April 25, 2007

Re: Status of Improvement Permit Application #07-5-17341

Lot #3 Johnny Faircloth Subdivision

SITE PLAN APPROVAL
DISTRICT RA30 USE DWMT
#BEDROOMS 3
Date 4/16/07

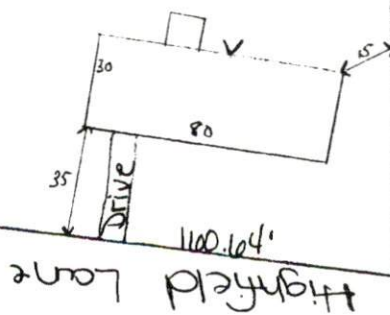
- ☐ 1. Property lines/corners not marked or labeled
- ☐ 2. House corners not marked or labeled
- ☐ 3. Directions not clear to property
- ☐ 4. Property needs brush or vegetation removed
- ☐ 5. Backhoe pits required
- ☒ 6. Other – Please move house as shown on the attached sheet. Submit new plot plan to Central Permitting and reconfirm through the automated phone system.

Move house location

so that it is not
with area shown

as septic and repair
area.
